**REQUEST**

Current Zoning: N1-A (Neighborhood 1)  
Proposed Zoning: UR-2 (CD) (Urban Residential, Conditional)

Approximately 29.33 acres located west of Steele Creek Road, south of Parkside Crossing Drive, and north of Settlers Trail Court.

The petition proposes to allow up to 169 single family attached dwelling units on a vacant site in the Steele Creek community.

INDEX OF SHEETS	
SHEET NO.	SHEET NAME
1 of 3	CONCEPTUAL SITE PLAN
2 of 3	TECHNICAL DATA
3 of 3	MASTER PLAN

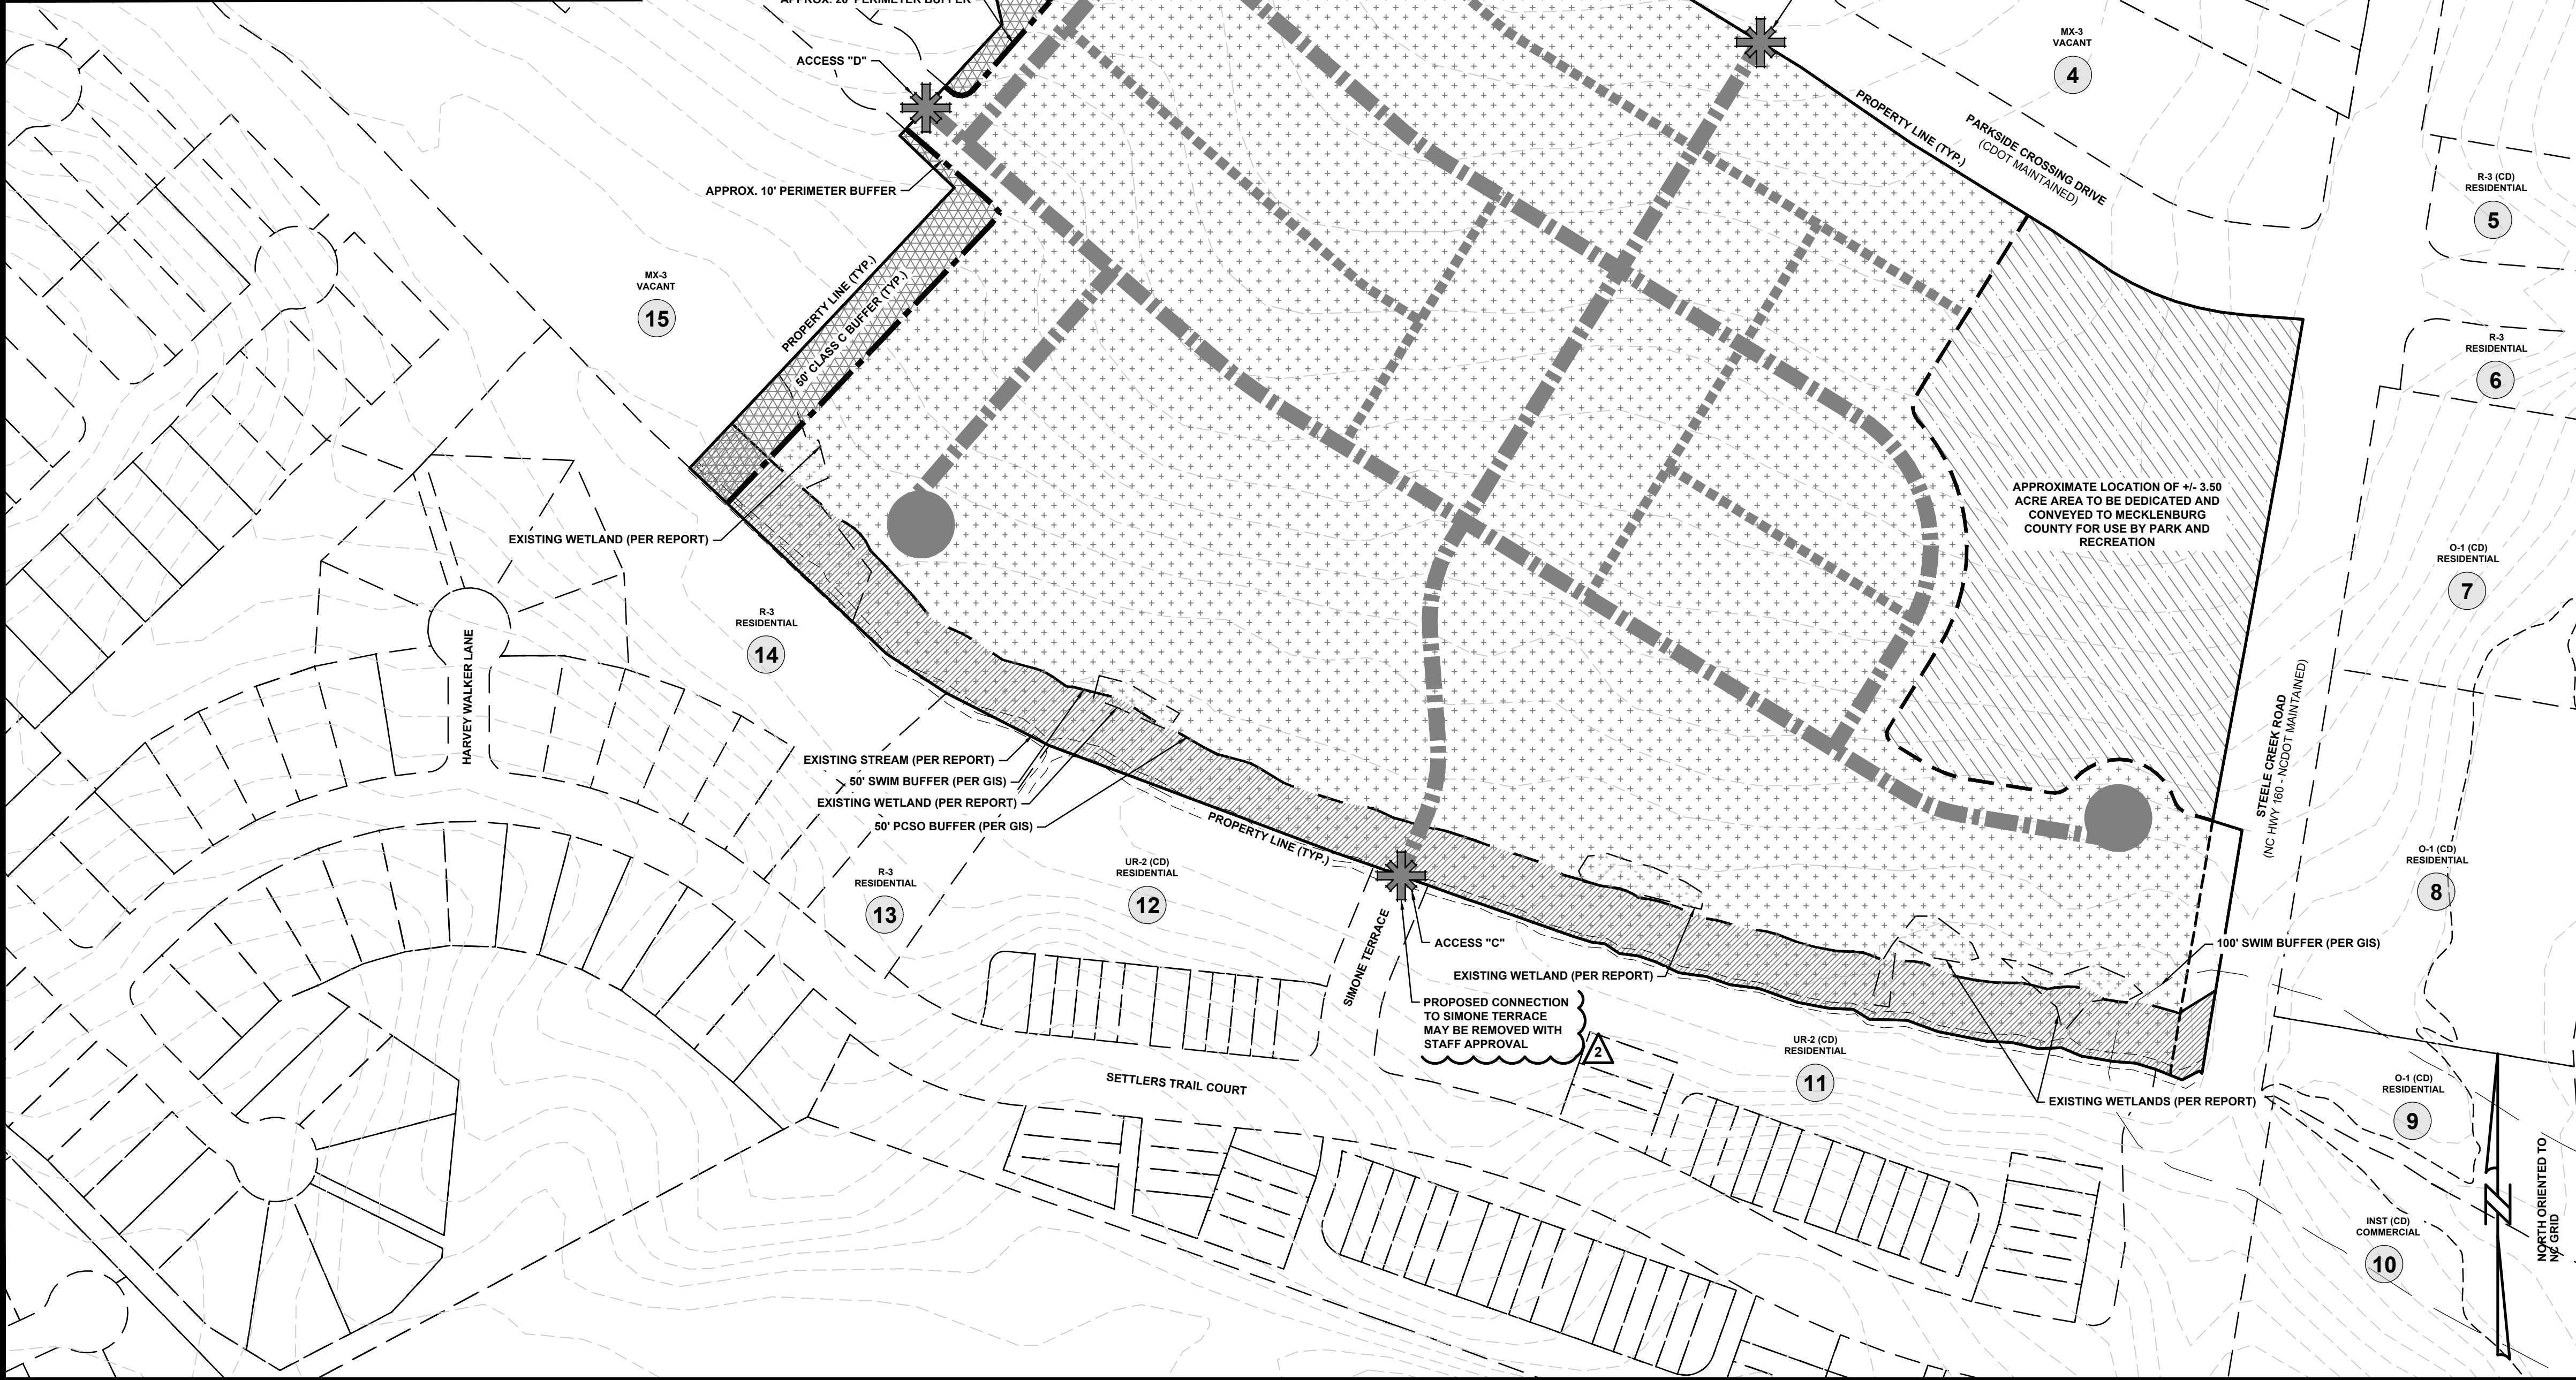
1. Tree save area on land to be dedicated to Mecklenburg County must first be platted and recorded as tree save and follow all tree save rules.
2. Label all references to proposed zoning as UR-2(CD).
